South Holland District Council

**Re: Reserved Matters Application for Residential Development of 60 Dwellings
Land Off Nightingale Way Sutton Bridge – H18-1167-19**

We refer to recent email communications and in particular your email dated 2nd January 2020 raising various comments and queries. This letter responds in detail to the points raised in the same order presented within your email.

DRAWING
PROPOSED DRAINAGE LAYOUT
(1 OF 2)

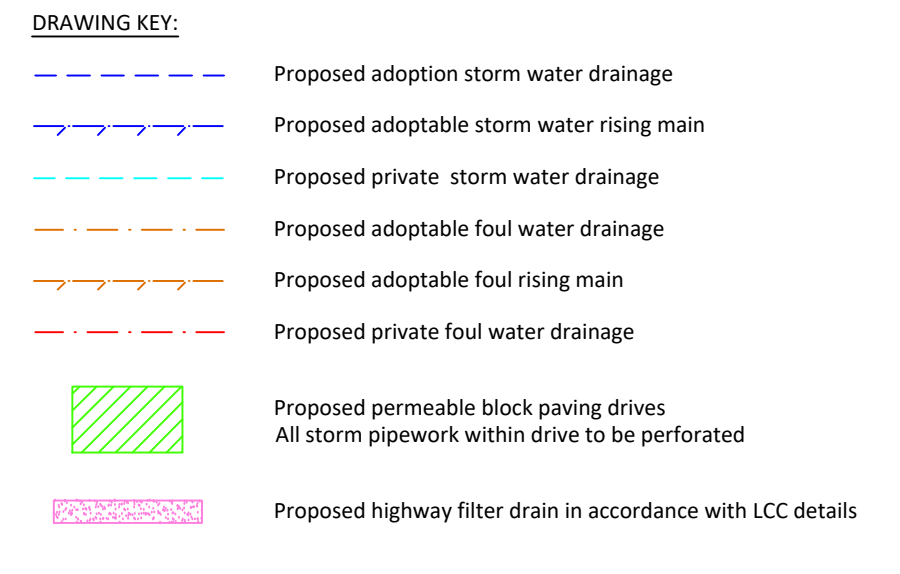
- 5.01 The filter drains and verges are part of the SUDS drainage solution for the adopted highway and are designed to meet the requirements of Lincolnshire County Council Highways department. As such it is expected that they will ultimately become part of the adopted highway.
- 5.02 You will have noted recent email communications between Jon Sharpe of LCC and Andy Webb of SEA Structural Engineers. The consultation comment was made in respect of filter drains running alongside Estate Roads B and C. The revised scheme drawings modify the filter drain arrangement in accordance with the detail requested by LCC.

TITLE
North of Nightingale Way, Sutton Bridge
Planting Plan 1 of 2

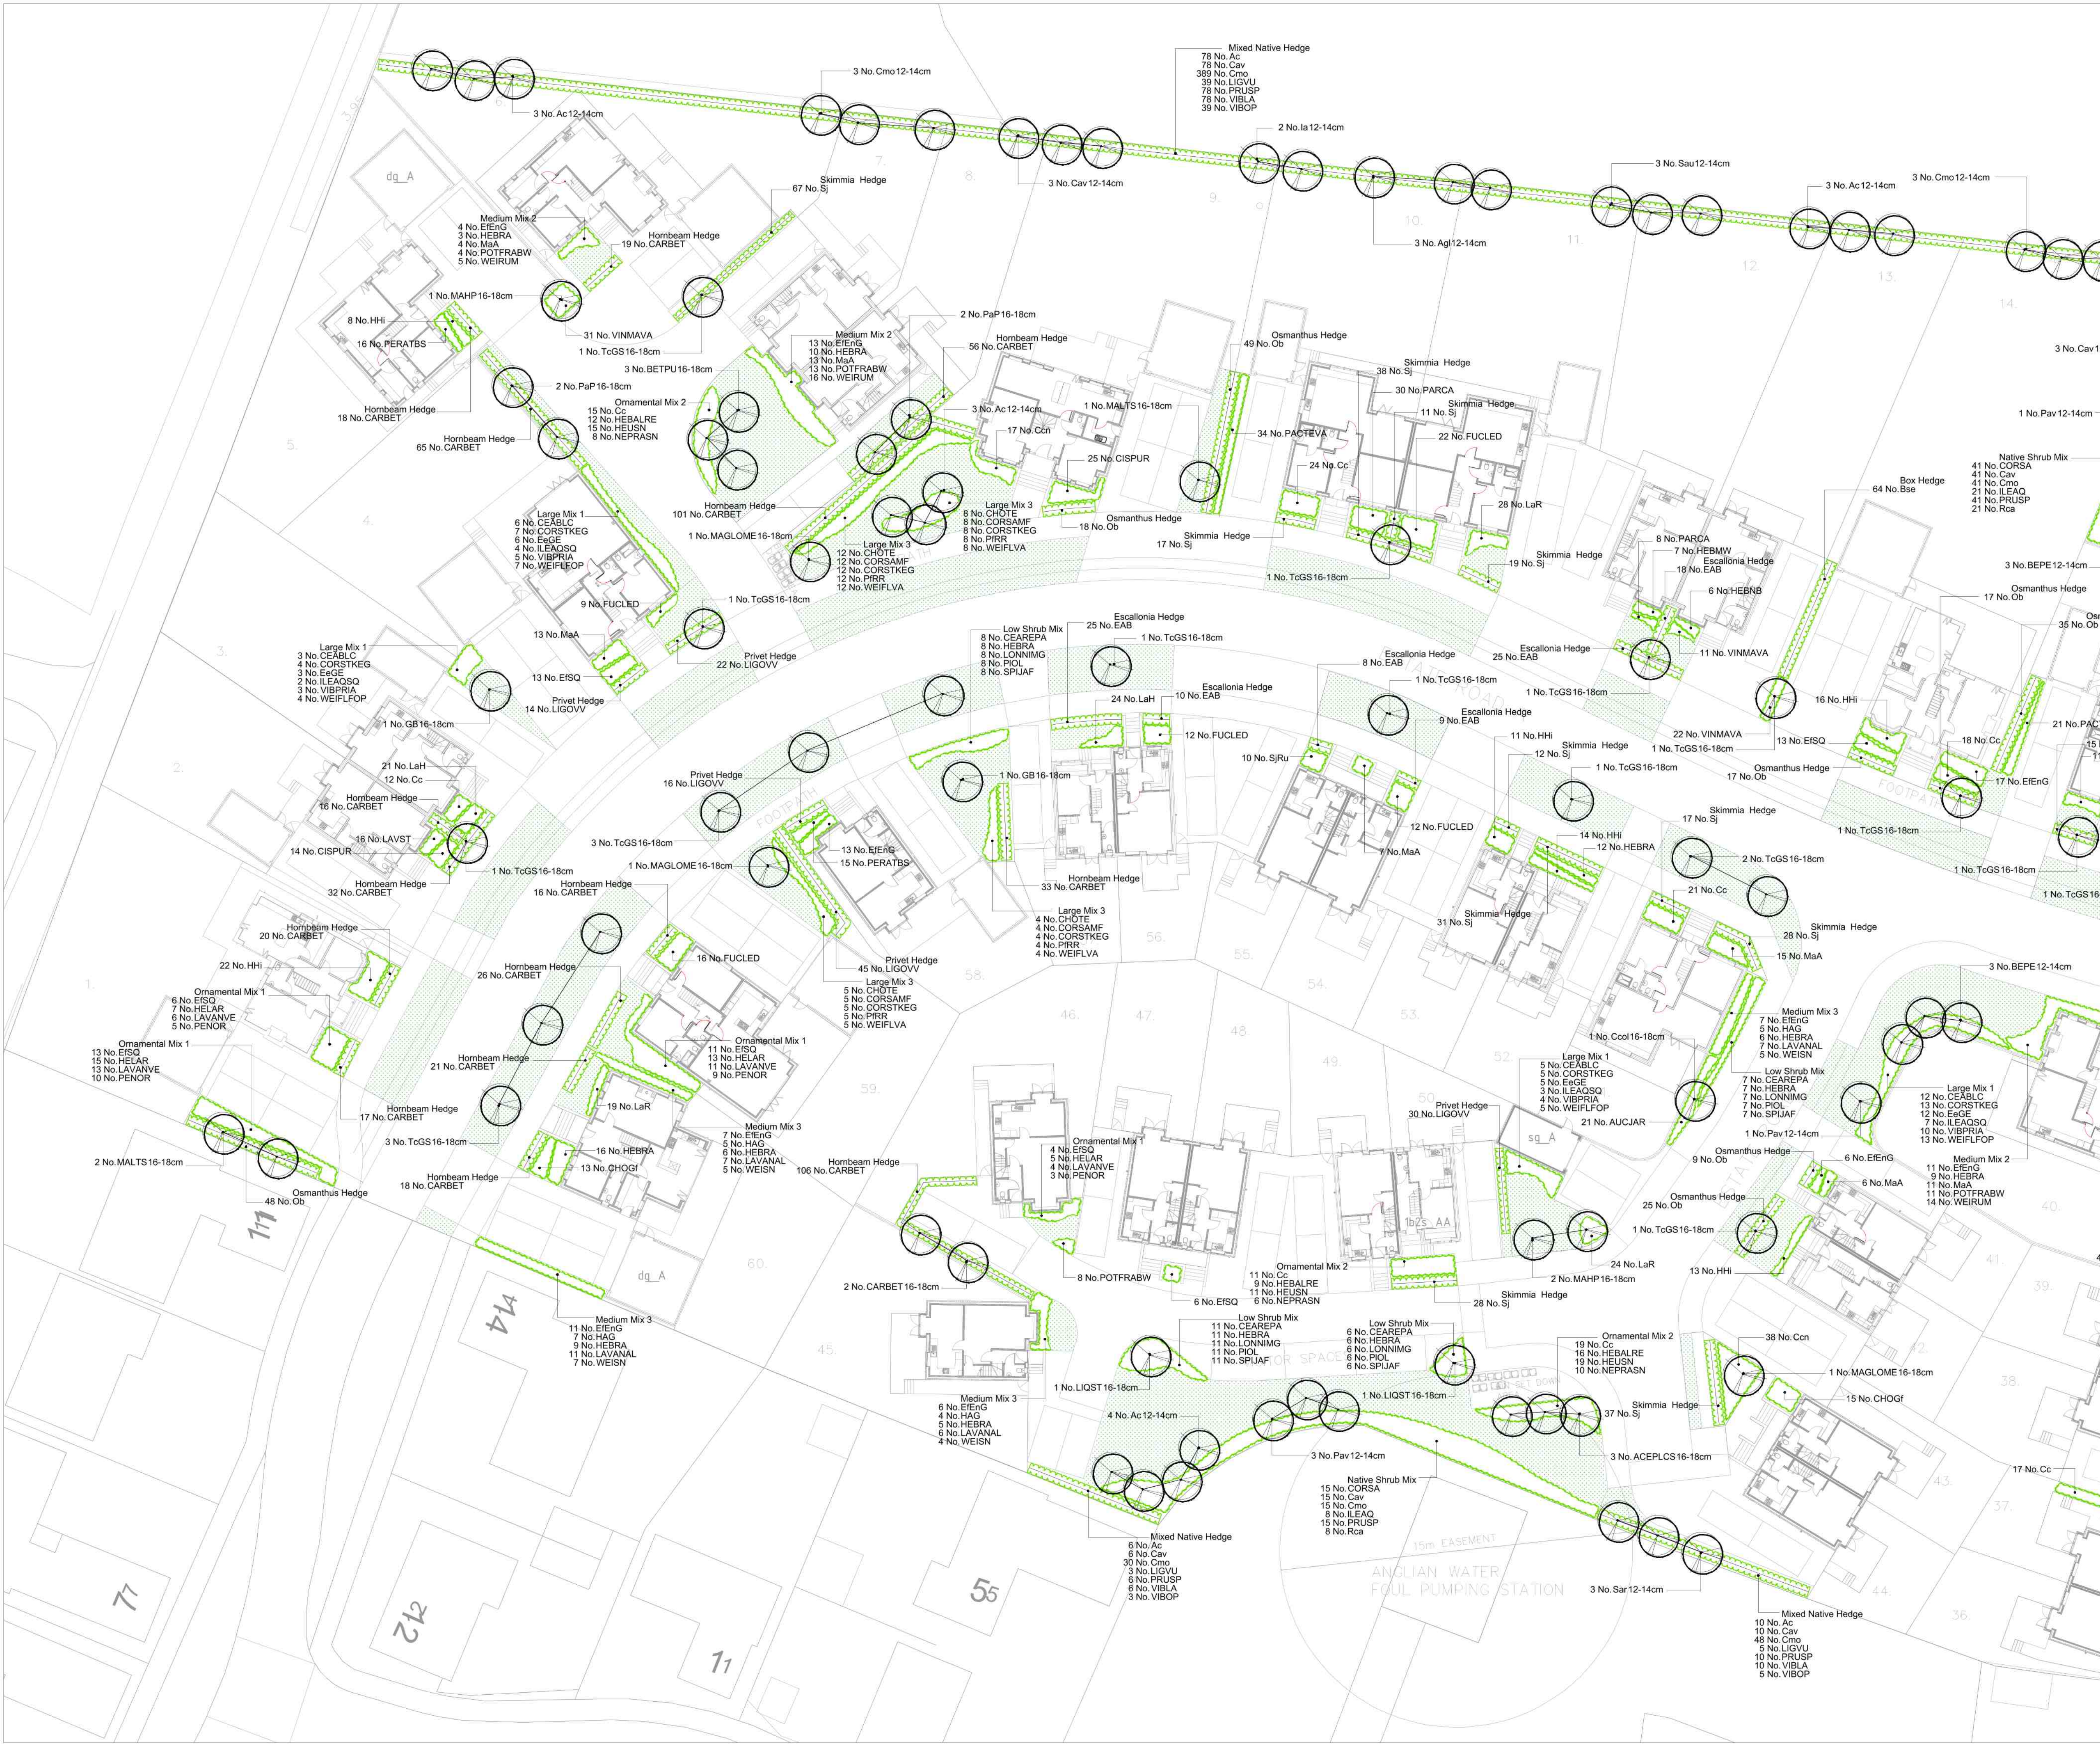
- 4.01 We take on board your concerns regarding surveillance to the footpath link and have added a south facing window to the Living Room of plot 24 (formerly plot 23) and removed a tree within the landscaped area adjacent the footpath link as requested.
- 4.02 We assume that the Ward Councillor has requested that bollards be introduced at the connection of the footpath with the access track located north of Granville Terrace and accordingly now show to bollards set within the footpath. It is proposed to install 2 No 1100mm high x 185mm diameter steel core polyurethane finished decorative bollards produced by Street Furnishings Ltd (Gravesham bollard shown on page 25 of the enclosed brochure)
